File no: SSD 9472; MC-18-00003

Re: SSD9472 - 151-161 Tallawong Road, Rouse Hill – Sikh Grammar School

ATTACHMENT A

**Figure 1:** Location of waste storage area for Primary and Secondary: northern corner of site (Source, PMDL, 2019).

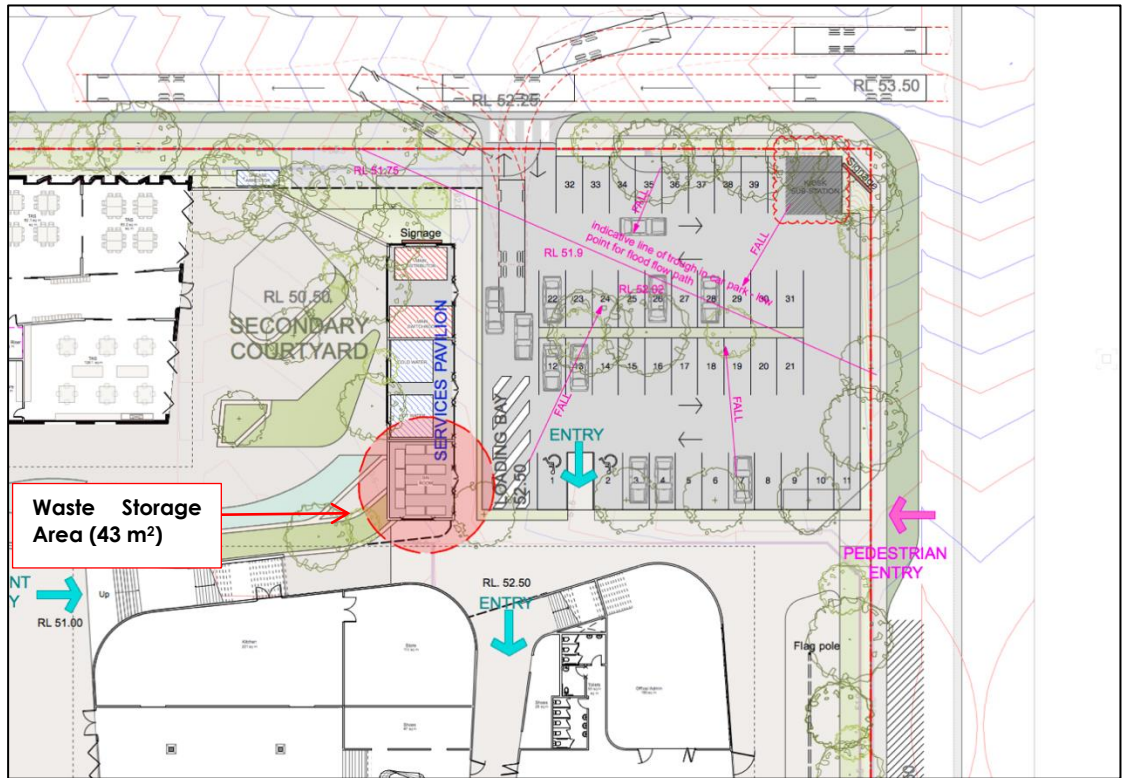
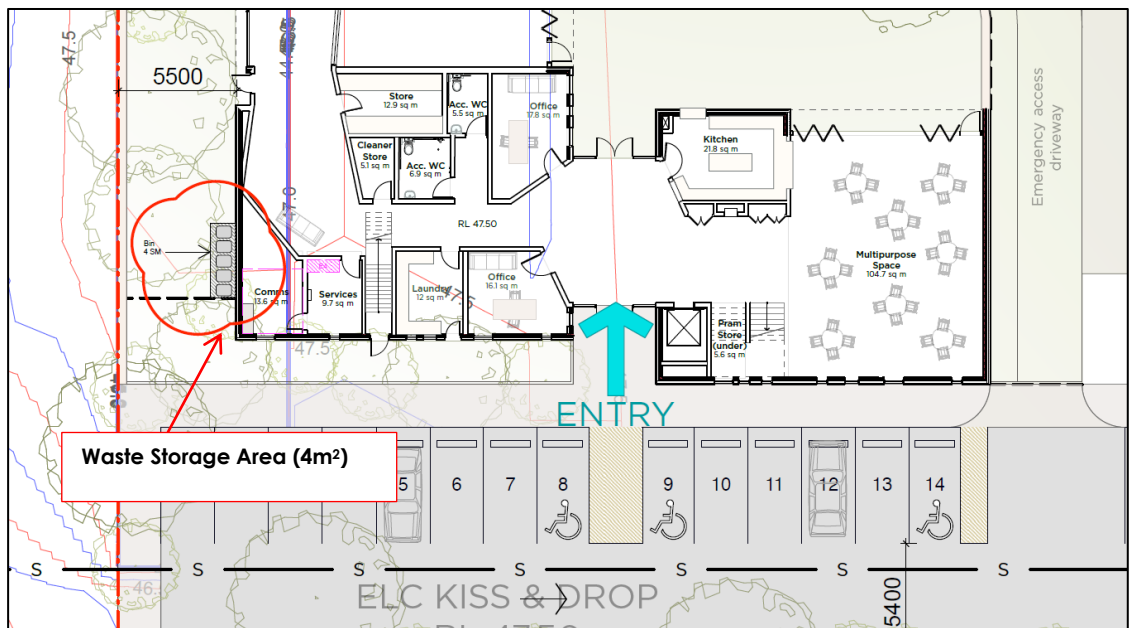
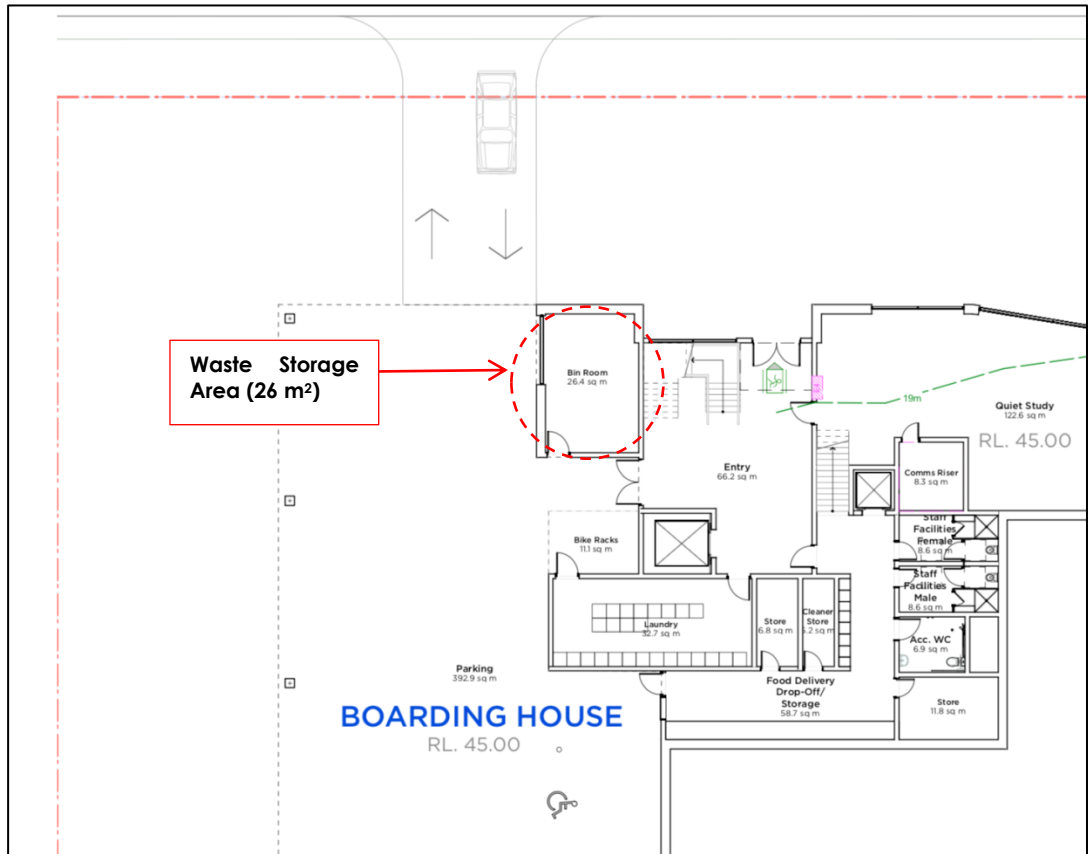
30. Privacy implications of the boarding rooms overlooking the residential lots on the west should be addressed.
31. Waste collection configuration must be wholly within the site. Trucks must enter and leave in a forward direction. The plans do not demonstrate that this is achievable within the design. Further, it is recommended that the waste and services pavilion is integrated into the design of the buildings to minimise its visual impact. The location of the pavilion is currently in a prominent location on site and will be highly visible. Collection areas should be adequately screened with landscaping and have suitable acoustic treatment to minimise impact on students and neighbouring development. Given that basement parking has been provided for the site, it is preferred that the service areas/waste collection is positioned within the basement. Refer to Blacktown City Council's Waste Section in regard to detailed operational requirements.

Stage 7 -Basement/Parking Plan

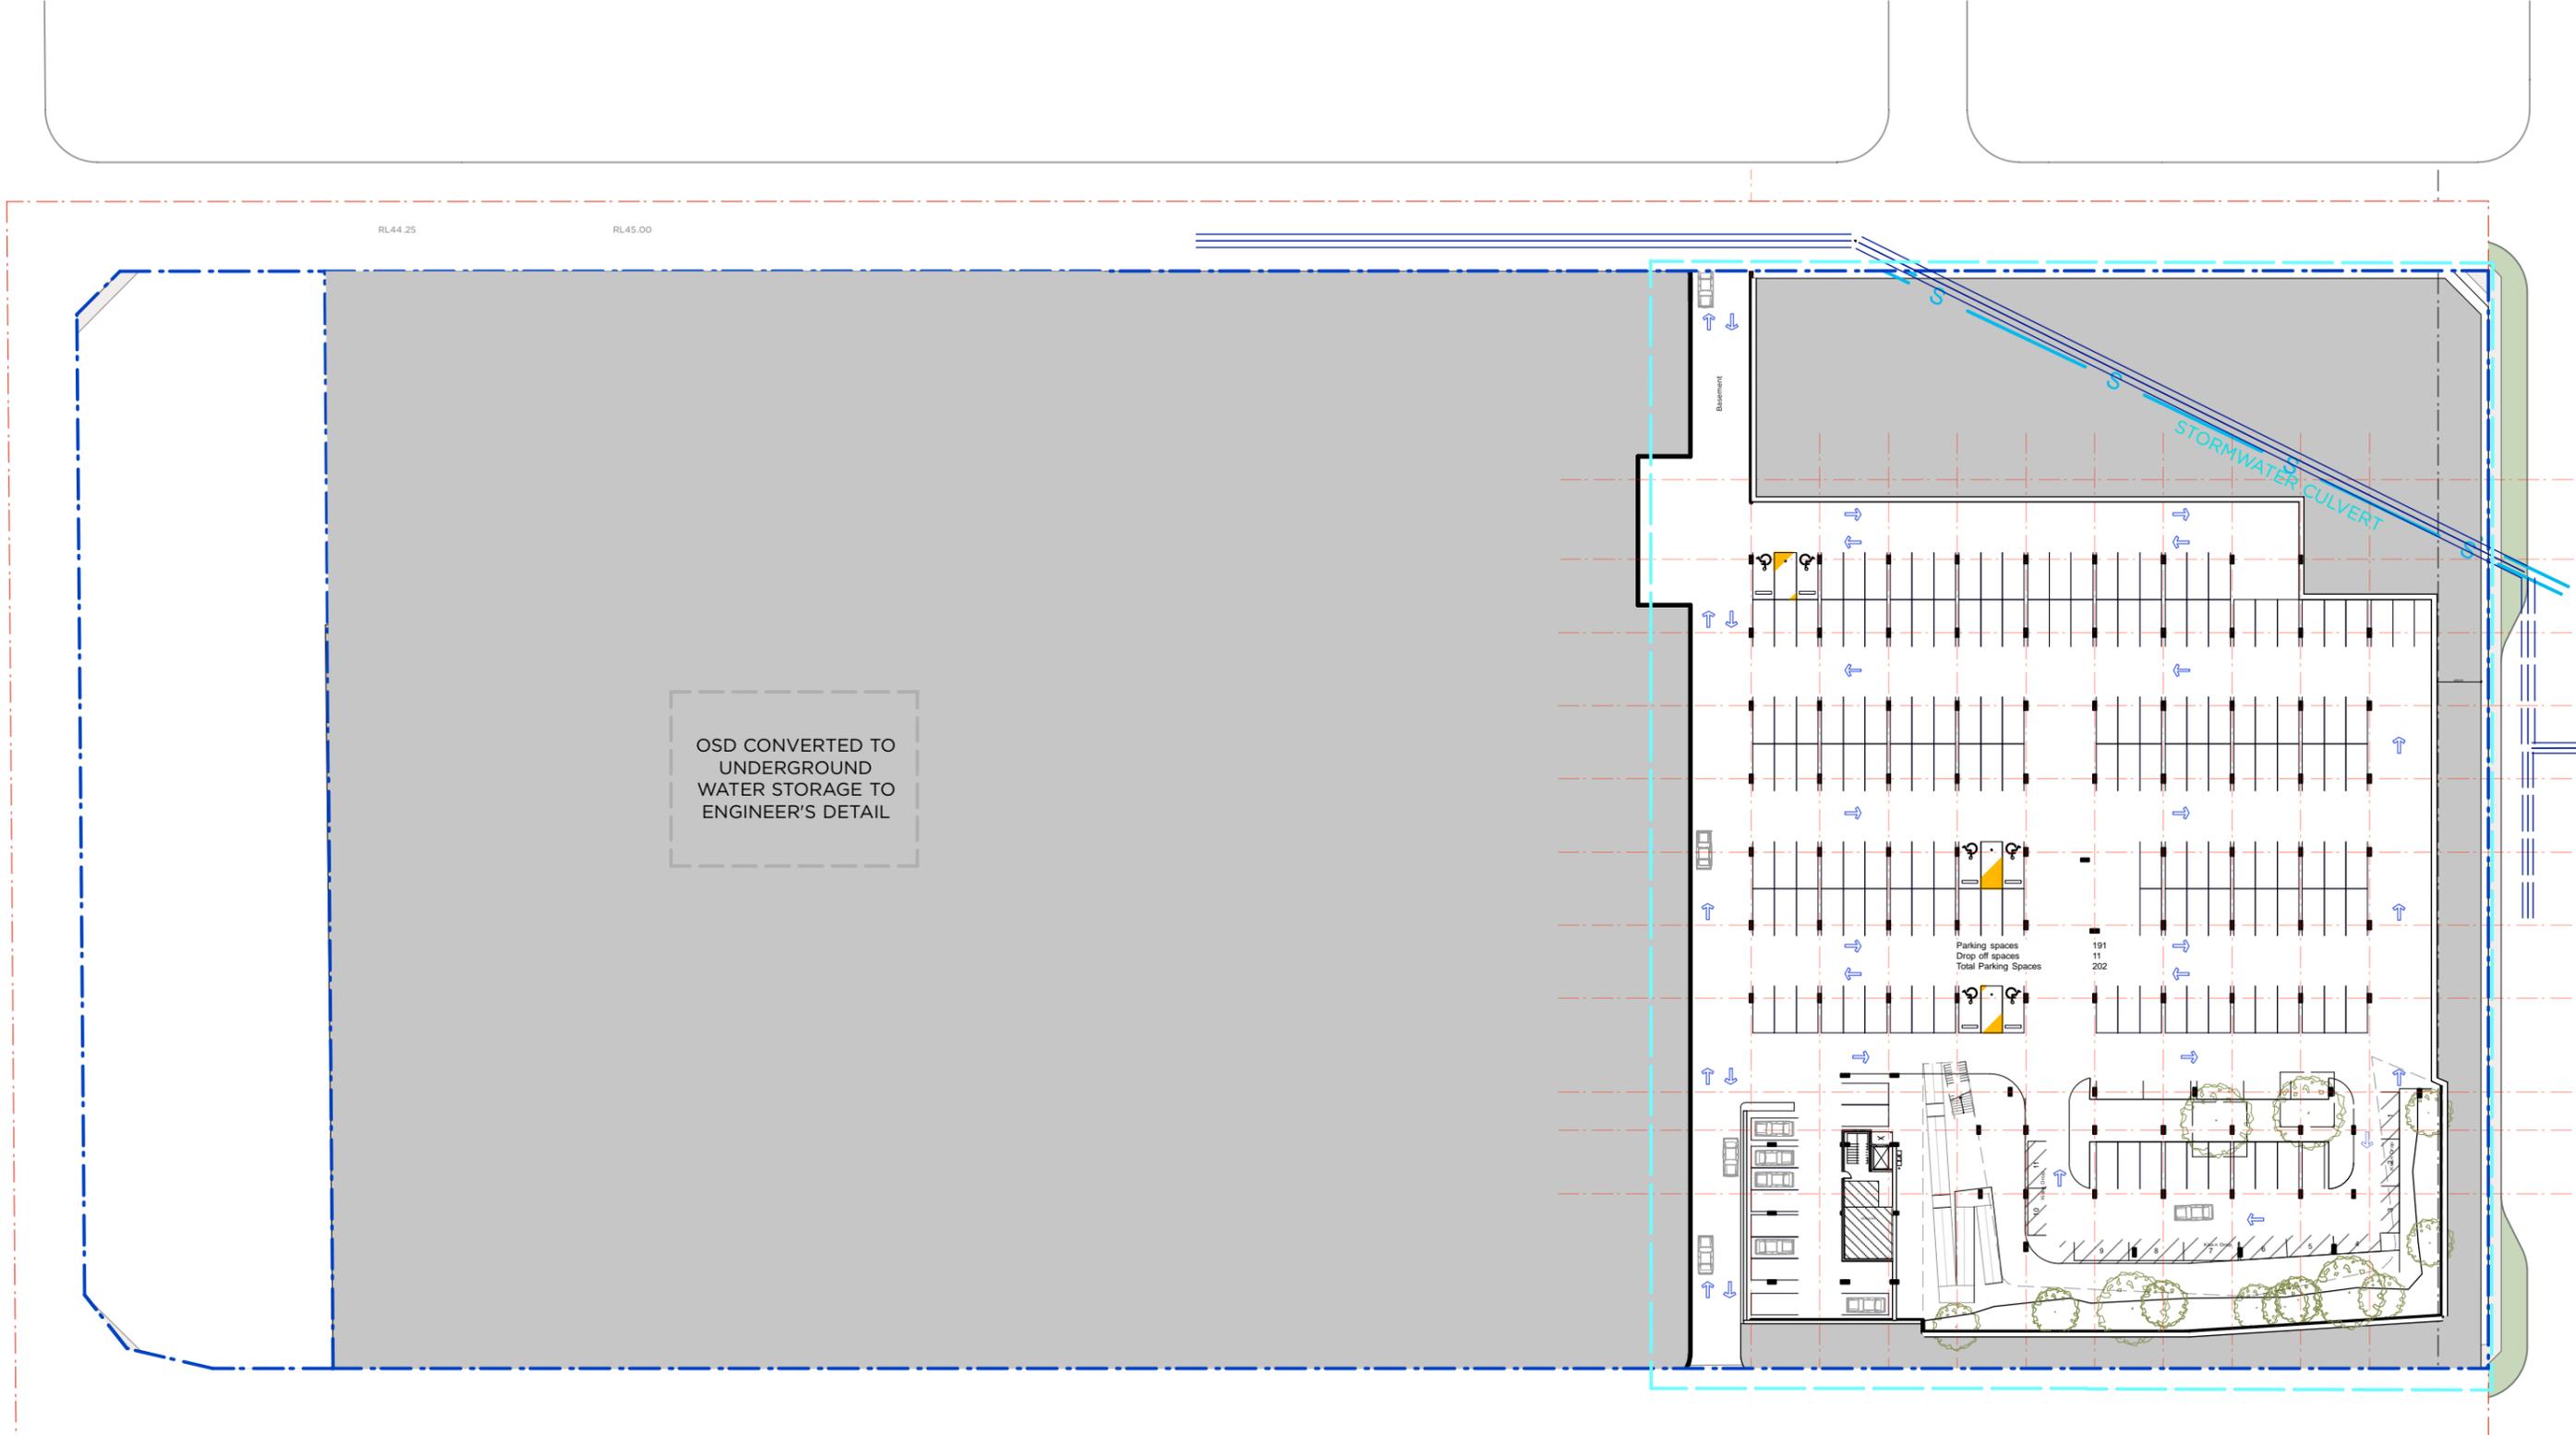
- v. The architectural plans show a basement car park north-east of the site. Demonstrate how the overland flows for 1% AEP storm event through the site are diverted from entering the basement.
